2915 - 076 - ANGMERING SPORTS HUB, WEST SUSSEX - RSA STAGE 1

## Main Site Tracking

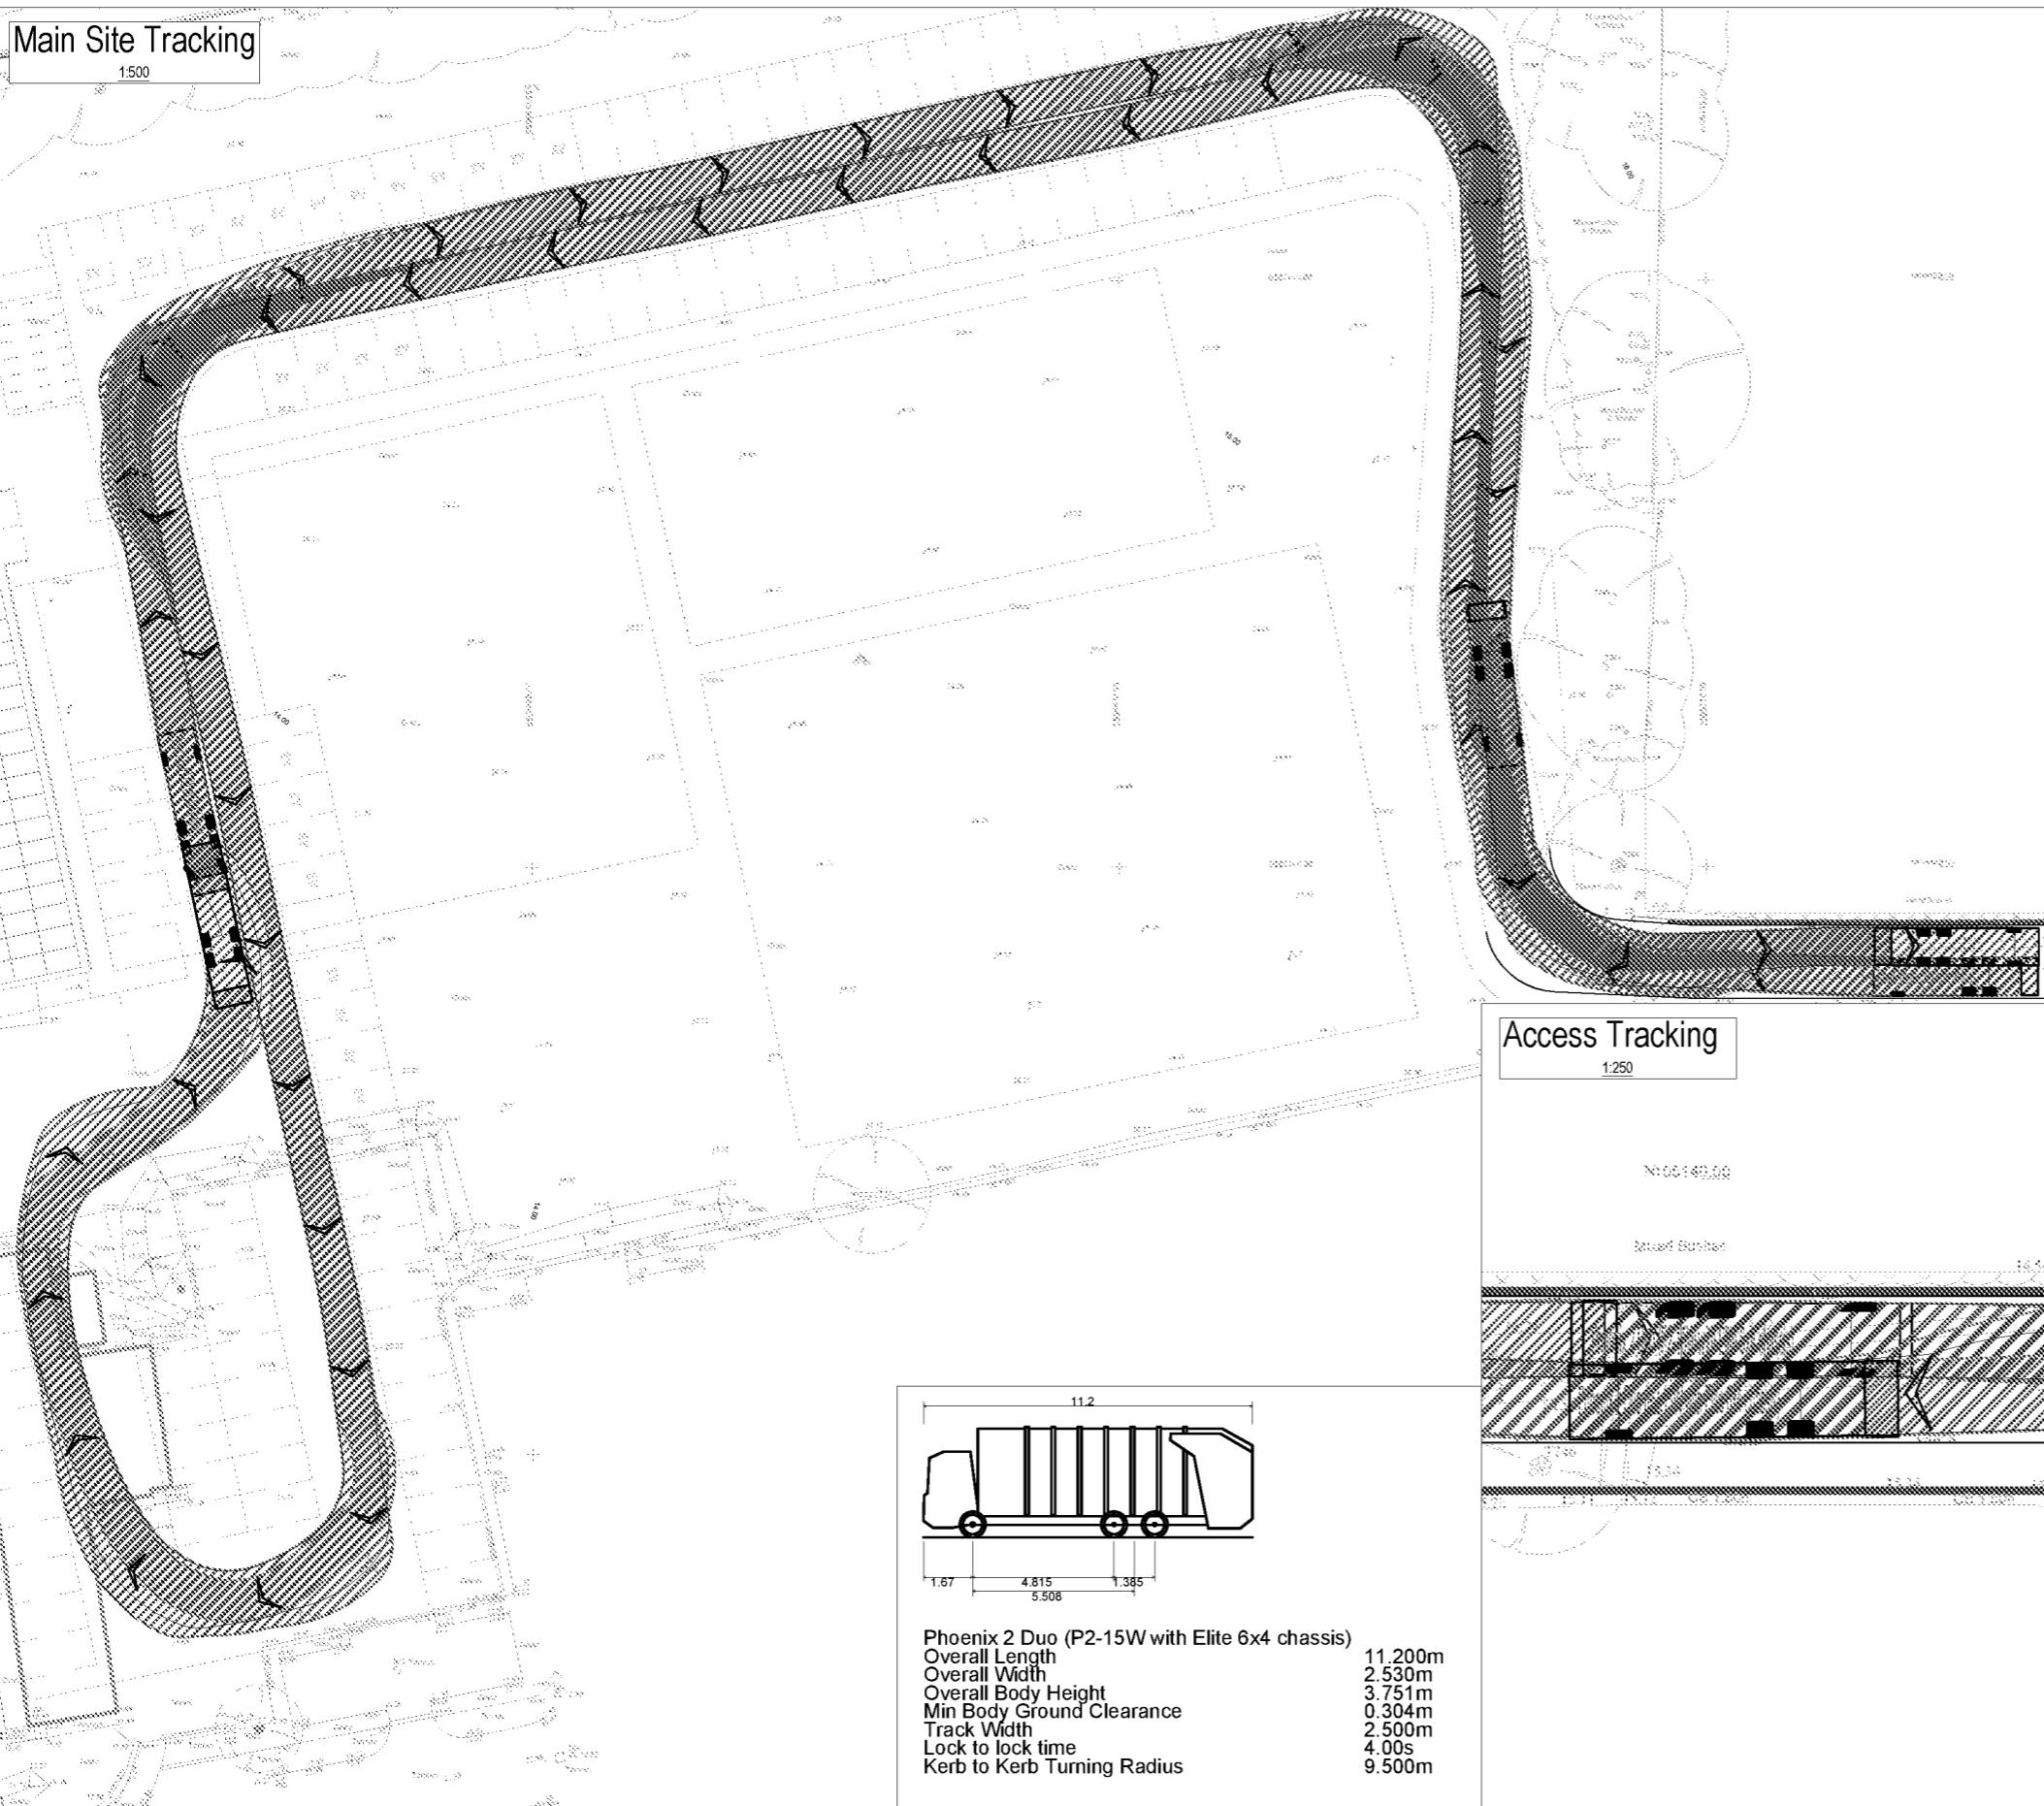
Audit Item No.	Audit Team Issue	Issue Location	Audit Team Summary	Audit Team Recommendation	Robert West Designer Response 10.10.2024
RSA-1-11.01	Obstruction of visibility splays.	At the proposed new highway access point in Arundel Road.	The lack of off-street parking for houses south of the new access and parking associated with the school will result in the visibility splay area being used for on street parking. Vehicles exiting the sports hub will therefore have reduced visibility of vehicles approaching along Arundel Road and may pull out and collide with those vehicles.	Provide enforceable parking restrictions to protect the new junction. It is recommended that these restrictions cover at least the adjacent access protection markings to the north and south of the proposed new entrance.	Accepted, double yellow line to TSRGD diag 1018.1 to be added to extend past suggested minimum distance - 2024.10.10
